July 29, 2013

RE: Staff Review Comments for Level I: Site Alteration & Single Family Home

Project Name: Hillcrest Avenue Street Extension/SF Home  
Applicant: Tim Higgins, Higgins Builders  
Planner: Nell Donaldson/Phil DiPierro

Project ID: 2013-170  
CBL: 260-C-18

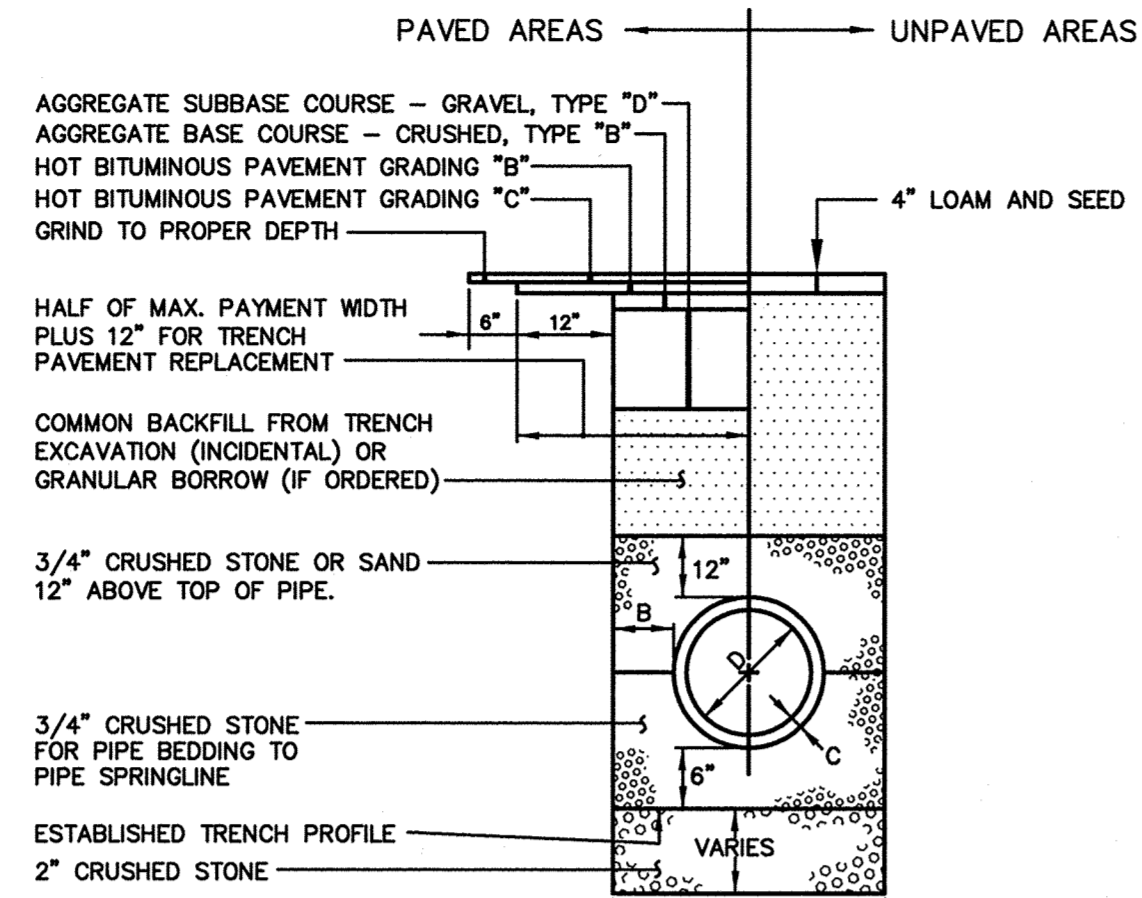
3. *The Applicant has requested a waiver from the requirement to install underdrains within the proposed street, as the existing, unaccepted and private portion of Hillcrest Avenue does not appear to have underdrains. DPS will need to provide a determination on this waiver request. If the waiver is granted, the Typical Residential Roadway Cross Section detail should be revised to not include underdrains. Note that the Department of Public Services has indicated that they are willing to waive the underdrain requirement.*
